**Re: Objection to MP08 0244 MOD 1 -
Modification Request for Mixed Used Development at 23-37 Lindfield Avenue
and 11 Havilah Lane, Lindfield**

1 SHADOW DIAGRAM - 21stDEC_9AM
5003 SCALE1 : 650

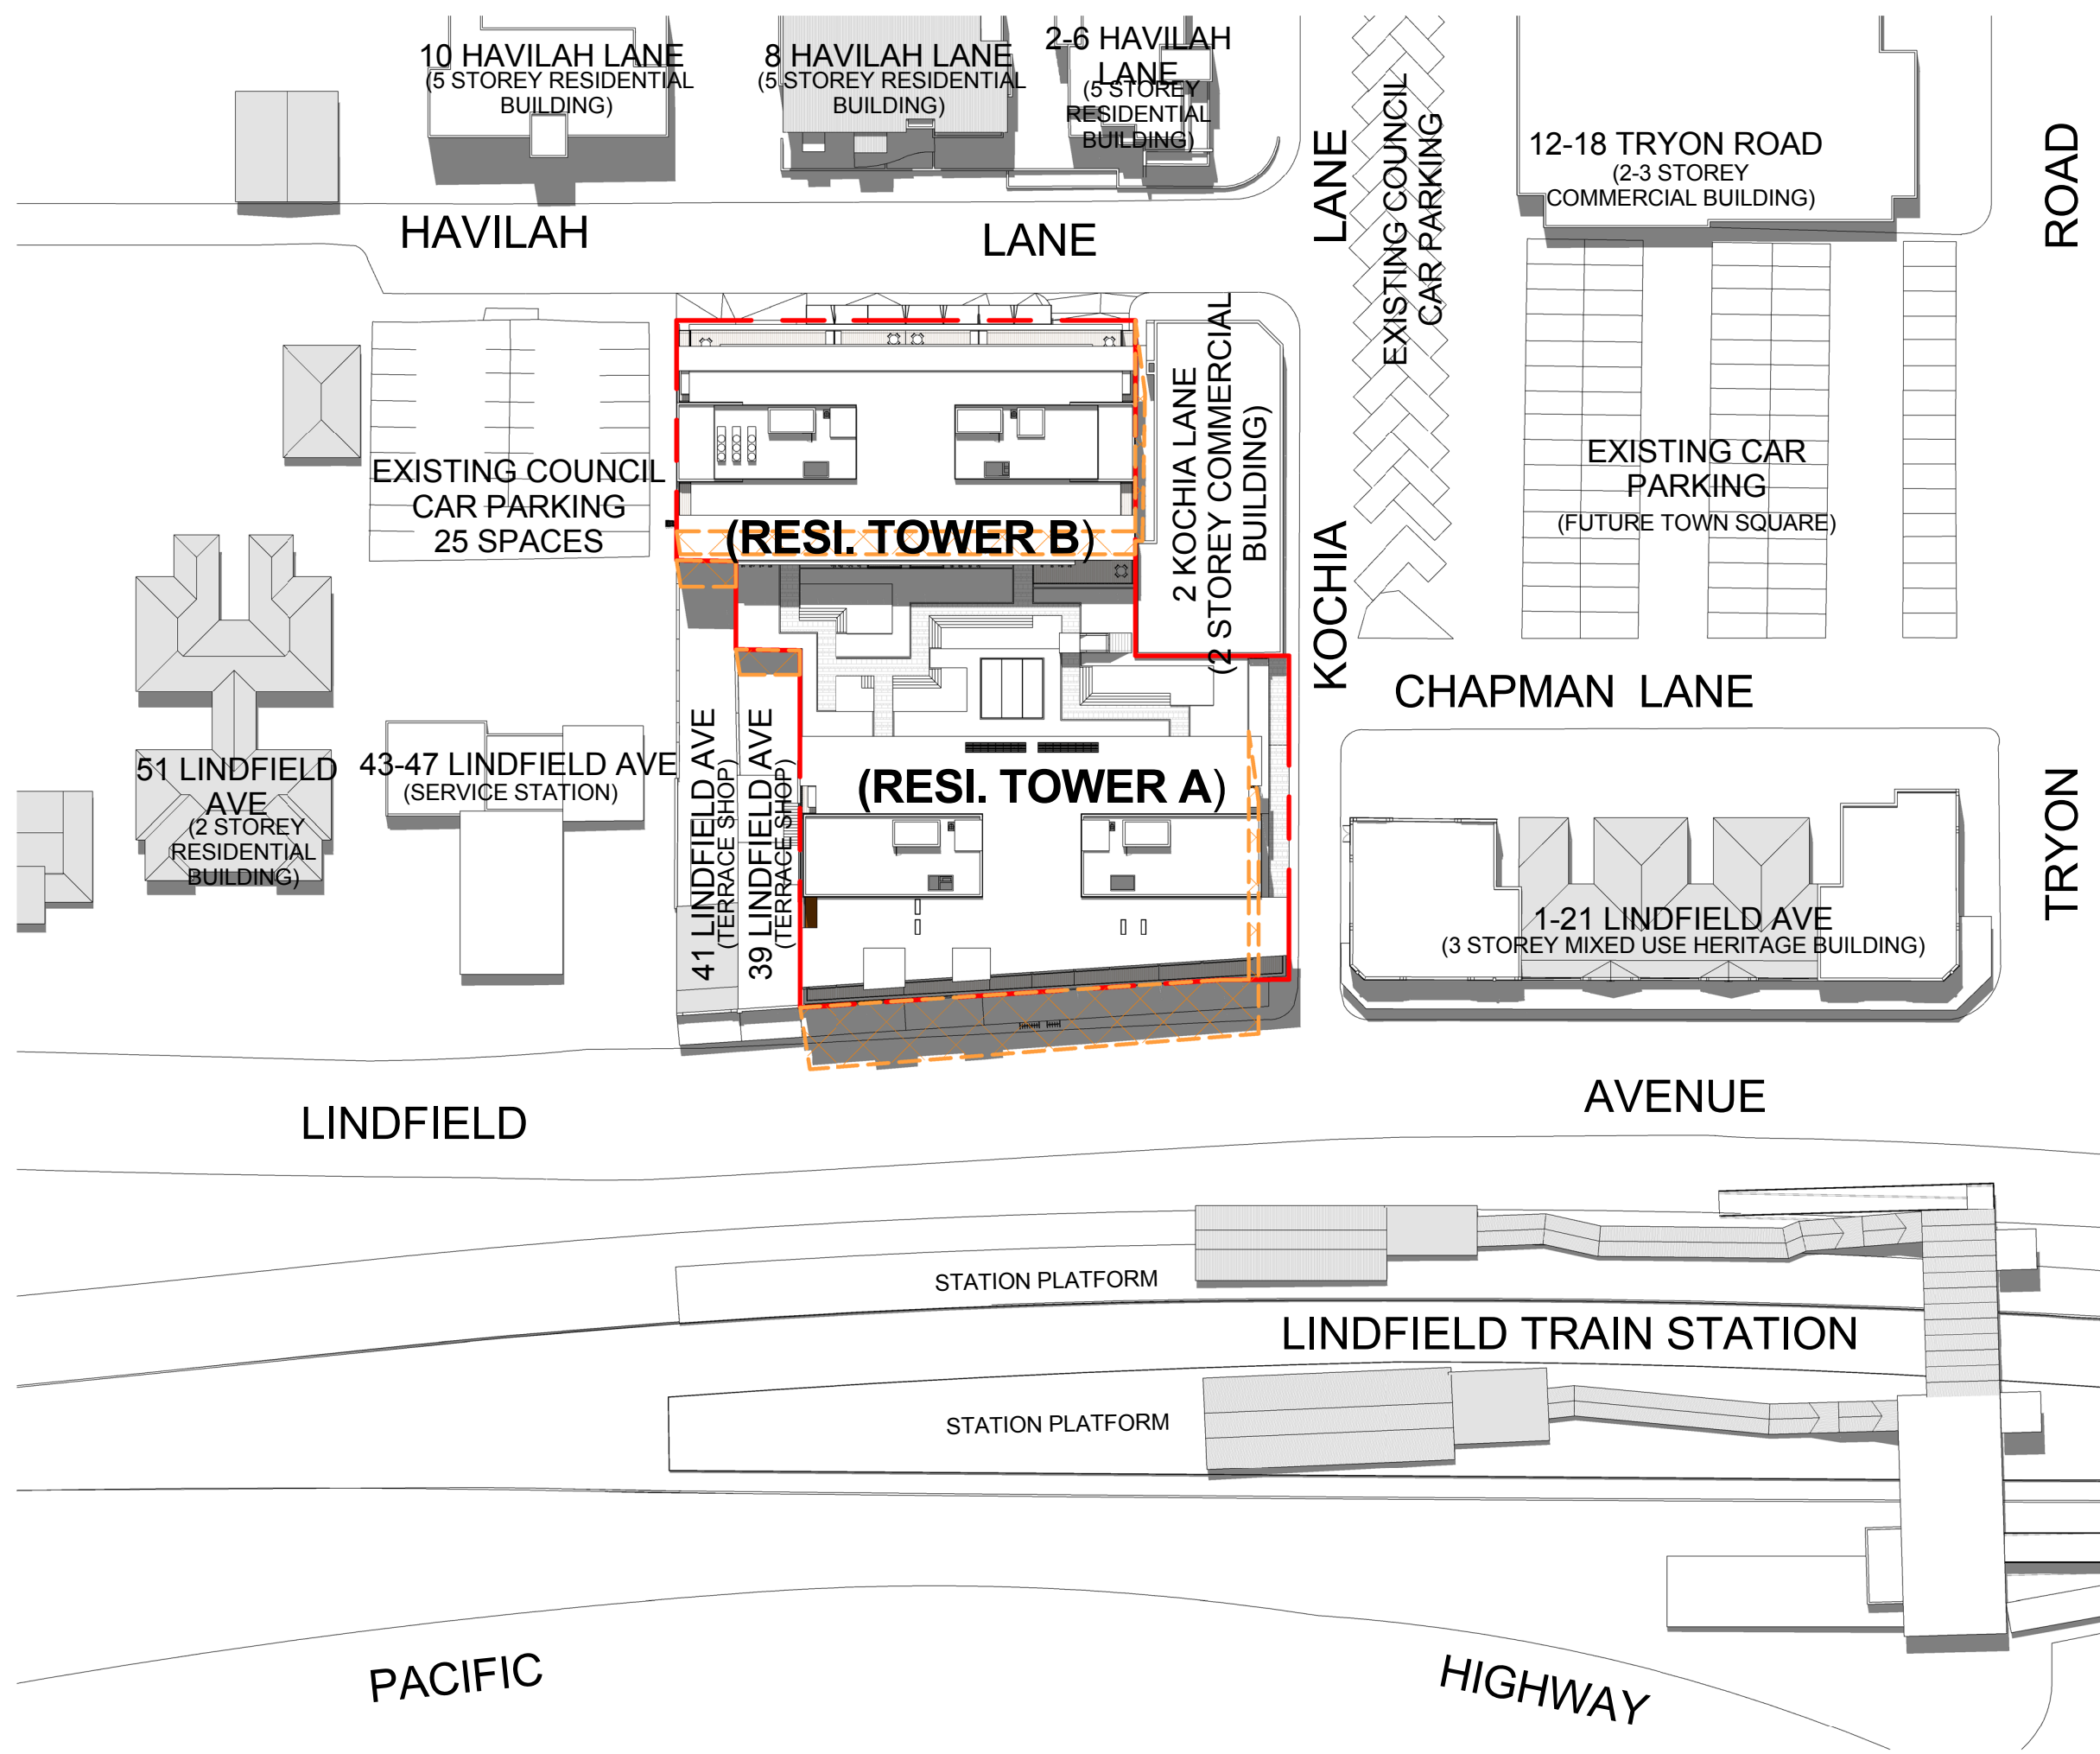
3. The **additional storeys create new adverse shadowing**:
 - (a) for **residents in the existing apartment blocks along Havilah Lane**, particularly after 3pm;

- (b) for the **popular outdoor café and central Lindfield hub area at 12 Tryon Road** in the afternoons, particularly in winter; and

(c) for all commuters on the city-bound Lindfield rail platform - instead of 50% of the year as was initially approved, this platform at the station will now be in shadow in the mornings for 75% of the year.

FIGURE 1.3 – MODIFIED SCHEME CAR PARKING

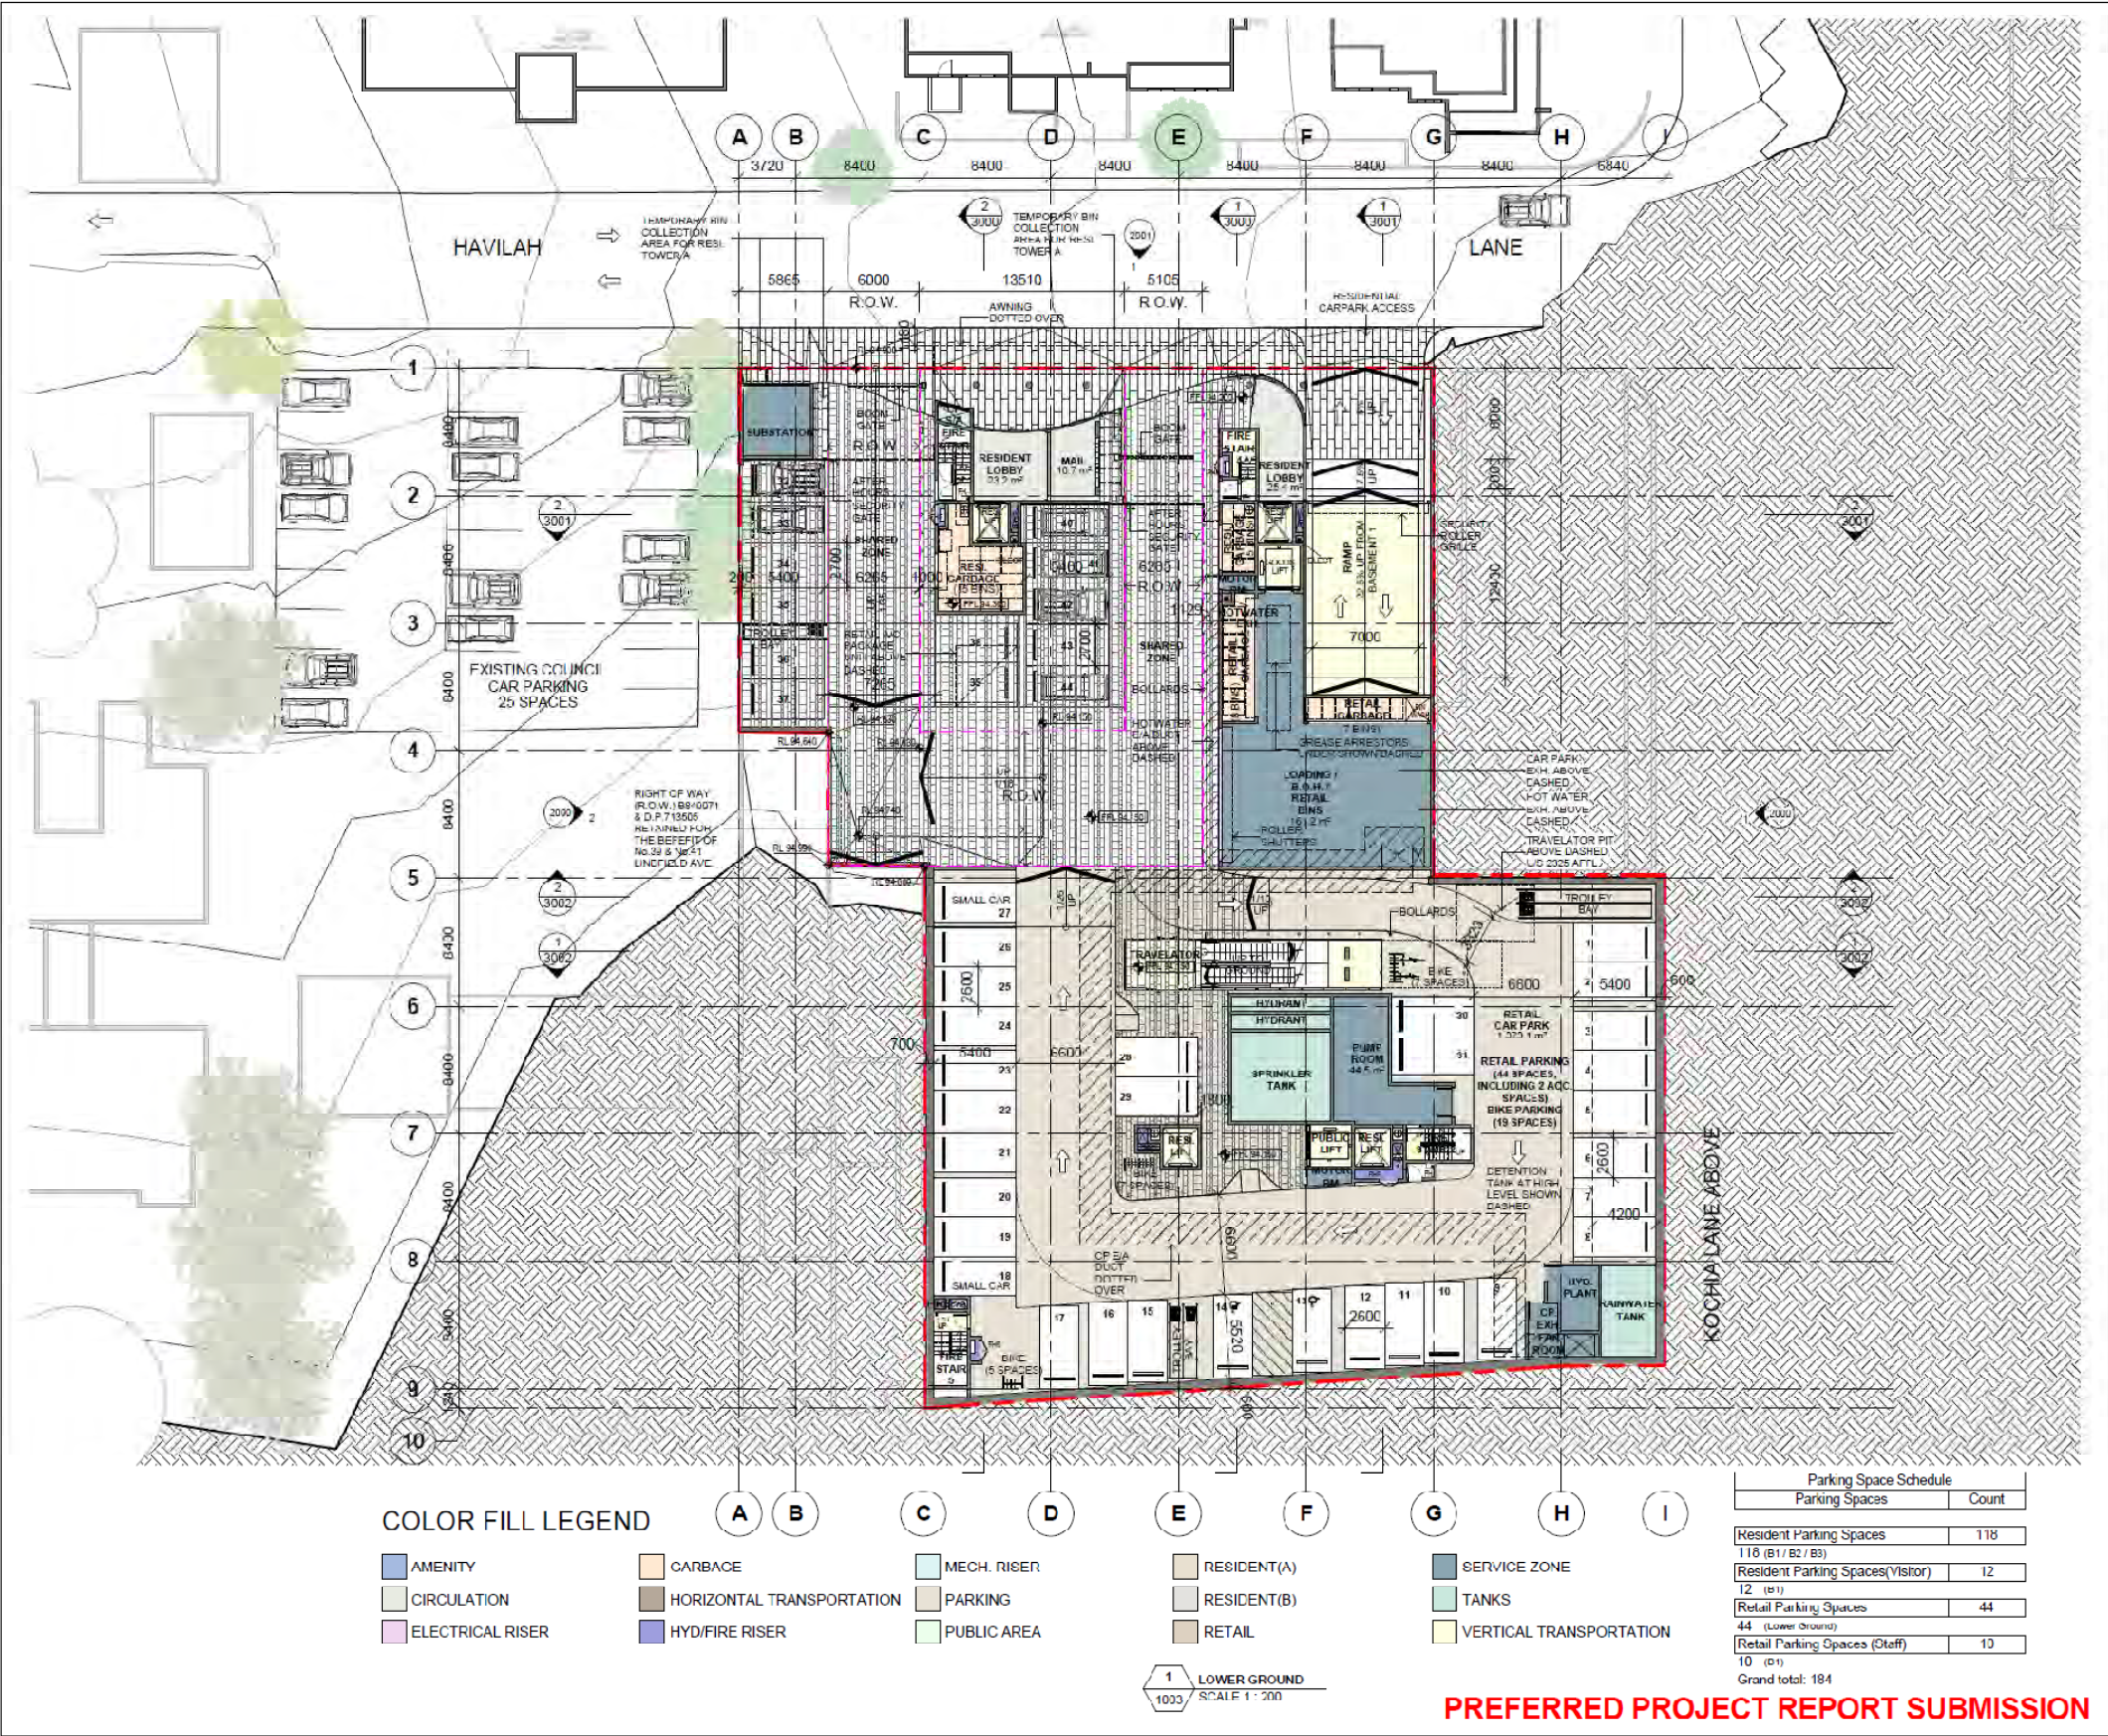
4. Car spaces were identified as inadequate (in the originally approved DA) for the retail component and this has not been addressed relative to the remaining retail space proposed. In fact, the Modification involves the reduction of 34 car-parking spaces that had been provided for in the original DA. It appears that the authors of this Modification are trying to include the 25 car-parking spaces off Havilah Lane on Council land as being 'available' to residents/visitors of the subject development. As Council property, these parking spaces would be available for the wider community, not reserved solely for users of this development. Further, we understand that the developers of the next site along Lindfield Avenue & Havilah Lane (immediately adjacent to the subject property) are at an advanced stage of negotiations with Council to purchase from Council the land where these 25 car-parking spaces are located (and which is in process of being rezoned). These 25 car-parking spaces are not, and are unlikely to be, available for residents/visitors to the property subject this Modification. So, the Modification reduces the property's own car-parking spaces by 34 & unrealistically claims access to 25 car-parking spaces currently owned by Council.
